ISH2 Written summaries of East Riding of Yorkshire Council's oral submission

Highways

Drawing Title
Environmental Statement Volume 3, Figure 14.2: Transport Routing and Existing Highway Network

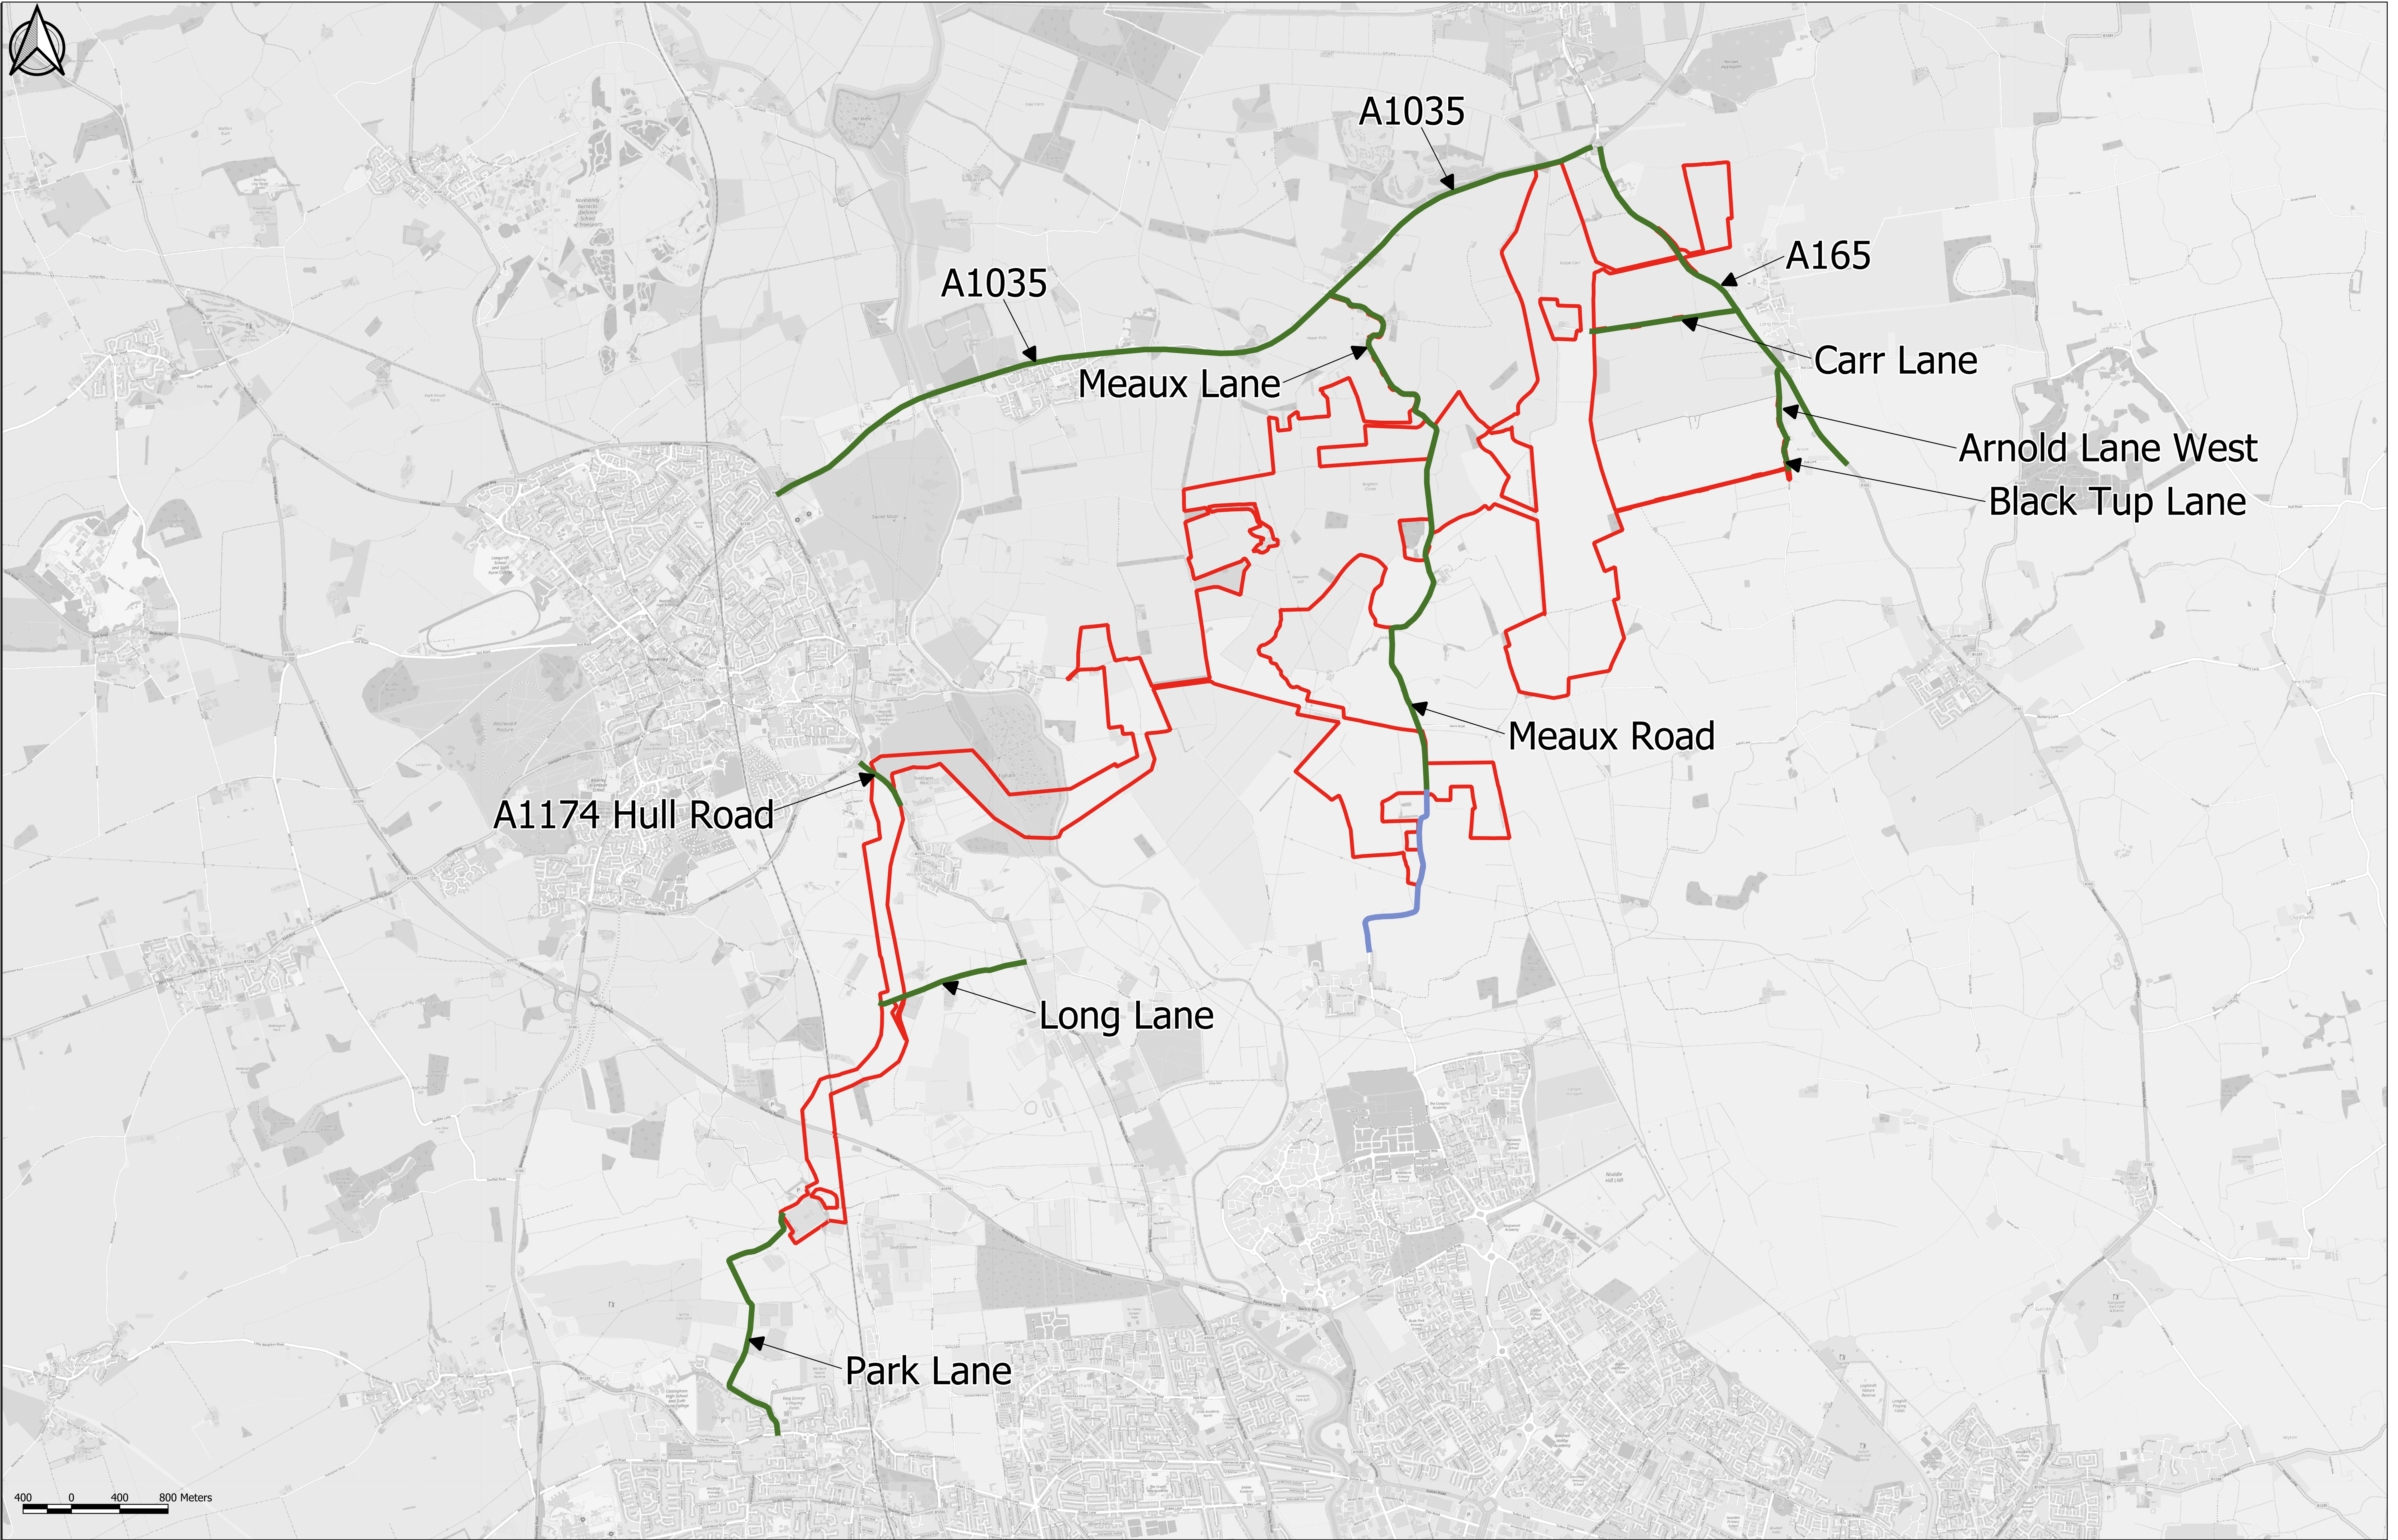
- There has been no change in ERYC's position on the use of Park Lane.
- The September 2020 traffic data is all that ERYC have available and that is why it is being relied upon, as there is no alternative. It is acknowledged that this could have changed in this time however we do not have data to support this.

- The Council consider the use of Park Lane for the proposed development would have an unacceptable impact on highway safety.
- The restricted hours for use of Park Lane between 9:30am and 3:00pm would mitigate the impact to some extent however would not fully alleviate our concerns.

- Mitigation suggested by ERYC would be to use an alternative access, such as those pending planning permission from the A1079, should Park Lane be accepted for use for the ExA, additional passing places, temporary traffic Regulation orders and parking restrictions should be considered.

- Confirm that there are currently no restriction on HGV's along Park Lane.
- There have been 17 recorded injury collisions along the route of Park Lane, resulting in 18 casualties. 3 serious, 15 slight. Of these, 5 were motorcycle riders, 4 cycle riders and 3 pedestrians. So the majority vulnerable road users.
